From: Andre Vernez <Andre.Vernez@shoalhaven.nsw.gov.au>
Sent: Monday, 23 April 2018 3:15 PM
To: Deana Burn
Cc: Cathy Bern; James Bonner
Subject: Shoalhaven Starches Modification 15 - Construct a Carbon Dioxide (CO₂) Plant at the Former Dairy Farmers Complex - COMMENTS FROM SHOALHAVEN CITY COUNCIL
Attachments: Shoalhaven Water Notice - 3A07-1008 - N8 (MOD 15).pdf

Please find below comments from Shoalhaven City Council in relation to Shoalhaven Starches Modification No. 15 (Construct a carbon dioxide (CO₂) plant at the former Dairy Farmers complex which forms part of the Shoalhaven Starches factory). In summary, Council does question whether this proposal would be a modification of the original approval or rather a new project in its own right, in accordance with the provisions of section 75W of the Environmental Planning and Assessment Act 1979. However, Council has no objection in principle subject to the following advice being considered. Comments have been segregated relating to the relevant sections of Council.

MODIFICATION NO. 15

TITLE : NEW PROPOSED OVERALL LAYOUT TANKER ACCESS PLAN VIEW		
DWG. No.	REV.	
GLPP16027-L1-005	A

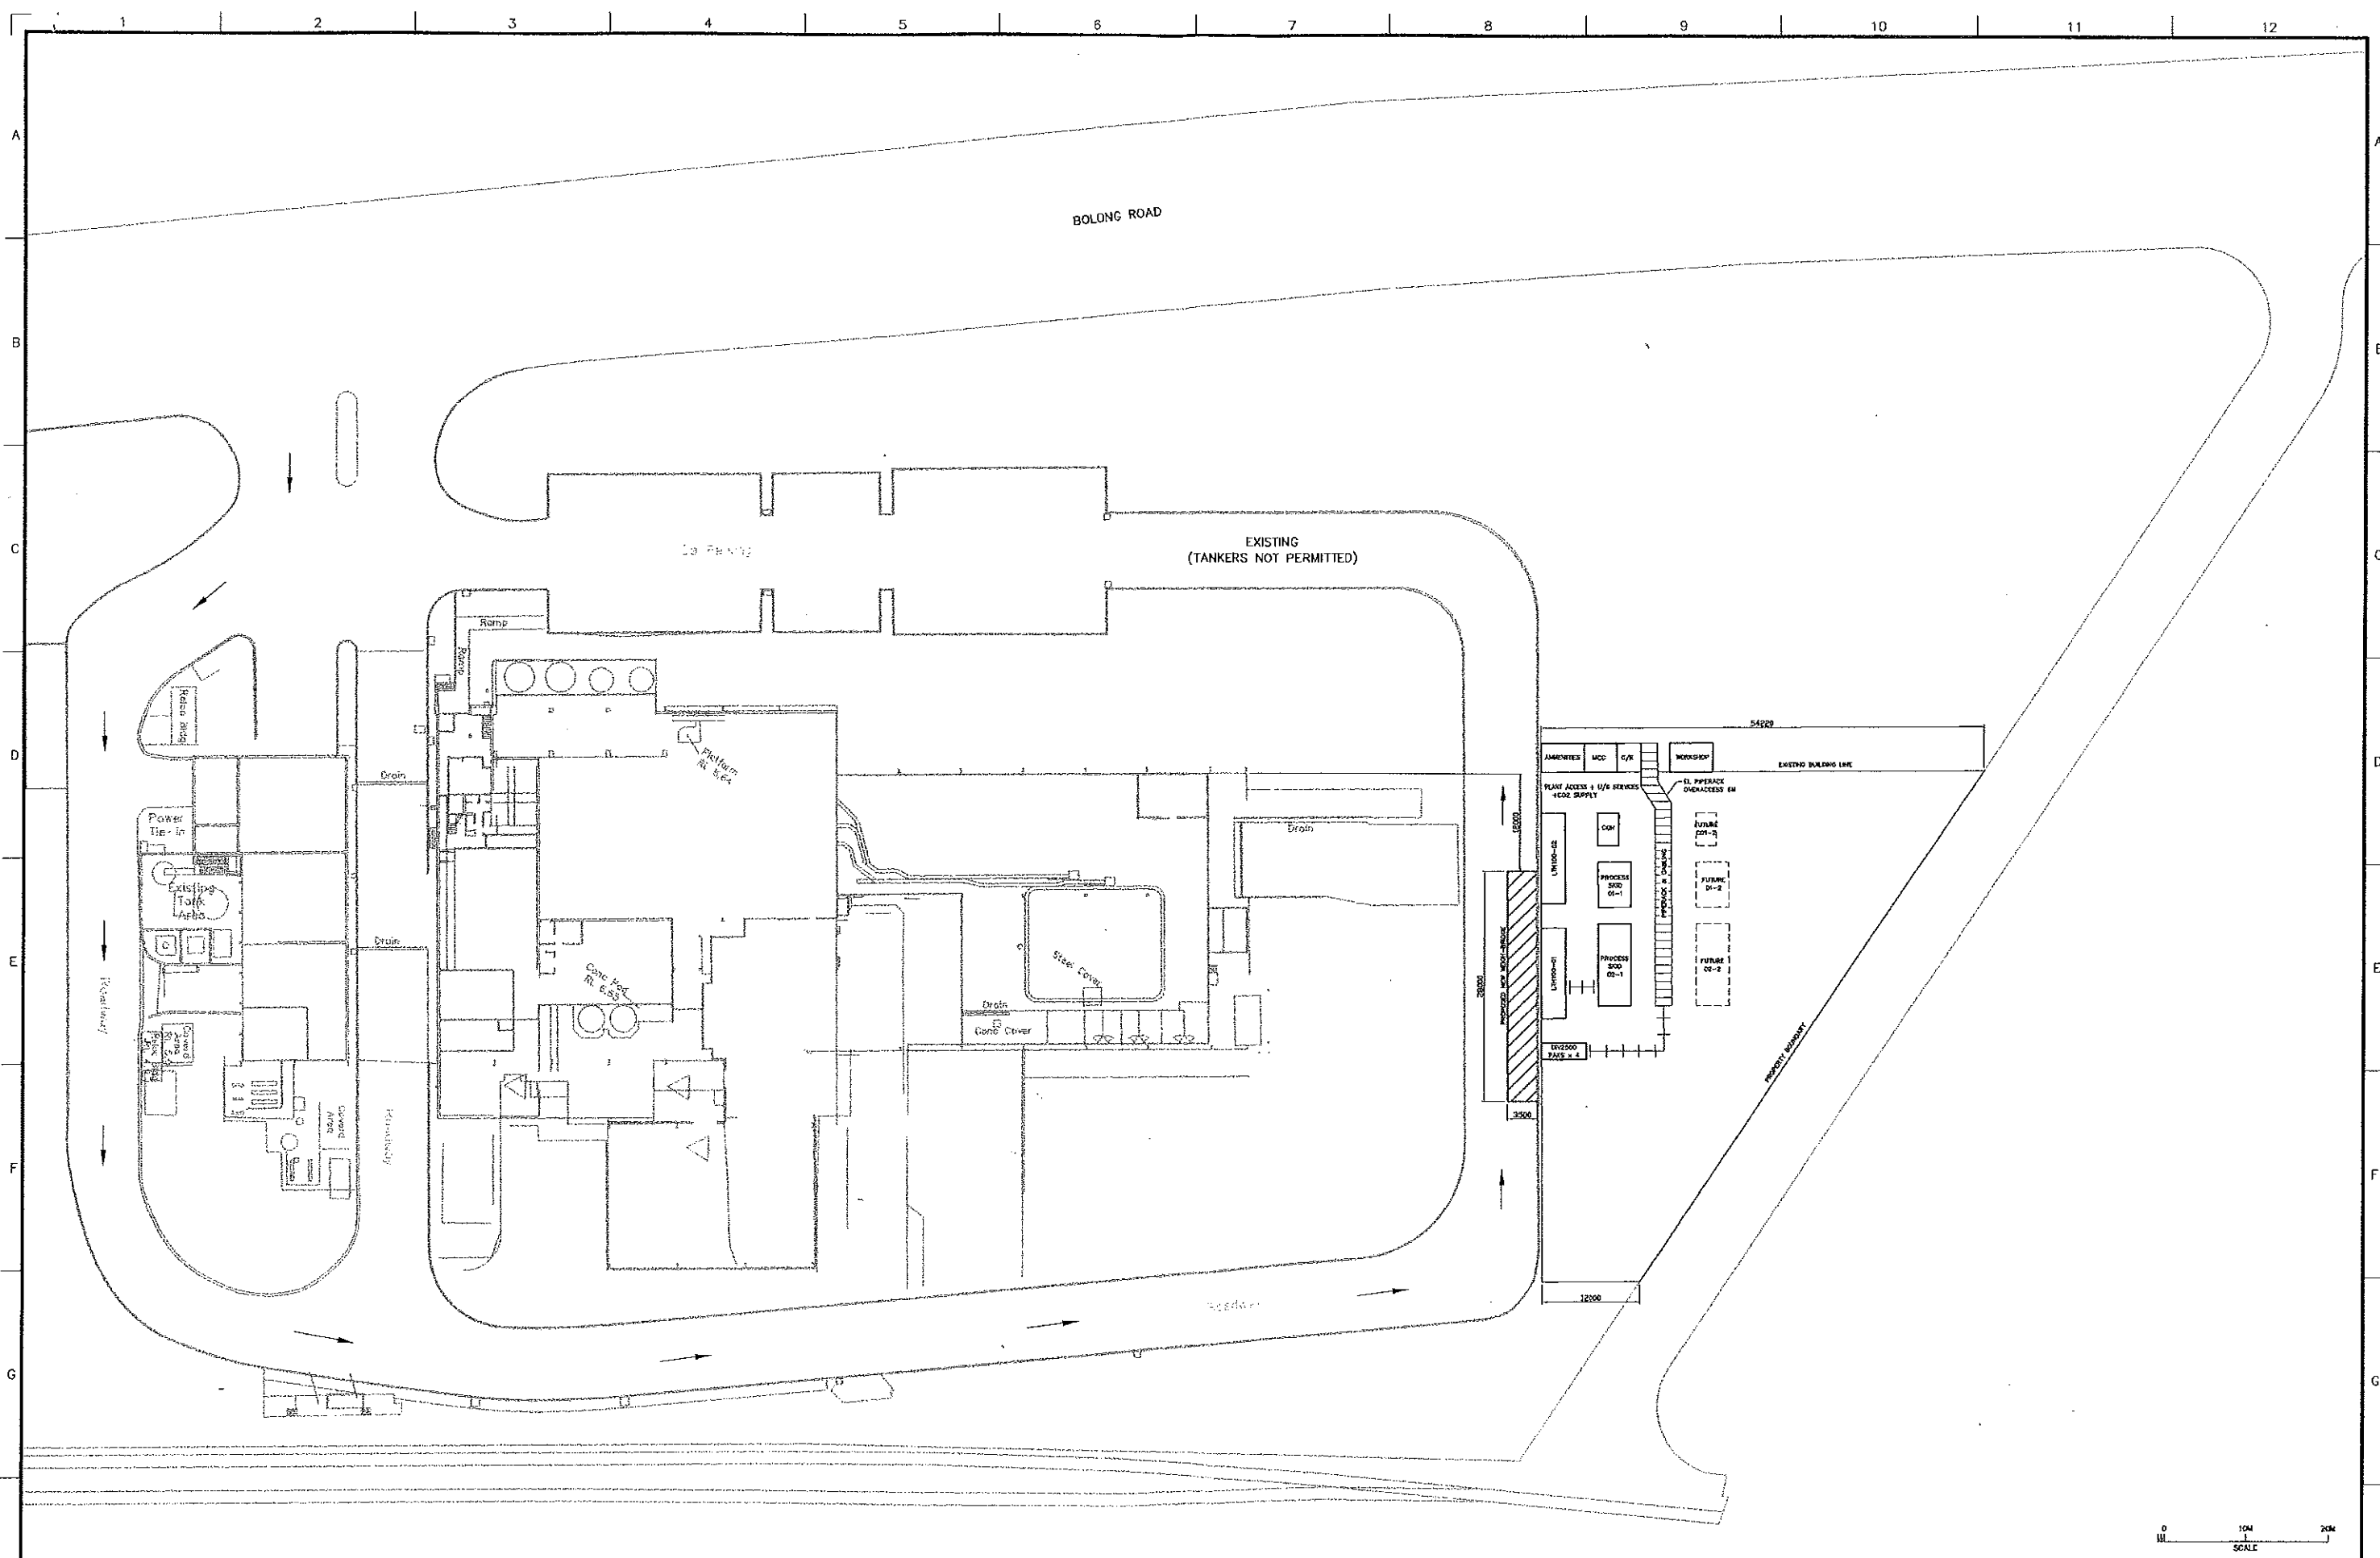
1. The Traffic Impact Assessment and plans indicate and show that B-Double trucks are going to access the site through the building. The submitted turning path plan shows the B-double truck also hitting the building between the roller door access points. Refer to the images below, which also show that the southern side of the building is for exit only.

- a. Clarification is required as to whether the development needs the B-Double trucks to enter the building other than for manoeuvring reasons.
- b. During Council's inspection of the site numerous semi-trailer tanker trucks were parked at the rear southern side where the B-Doubles are proposed to access the site. The submitted turning path plan also shows these tankers. The proposed location for parking of these tankers needs to be confirmed.
- c. The existing approved tear drop access/exit point onto Bolong Road is not a mountable island so access around the building from Bolong Road to the western side could be a difficult manoeuvre to achieve, as shown in the image above.
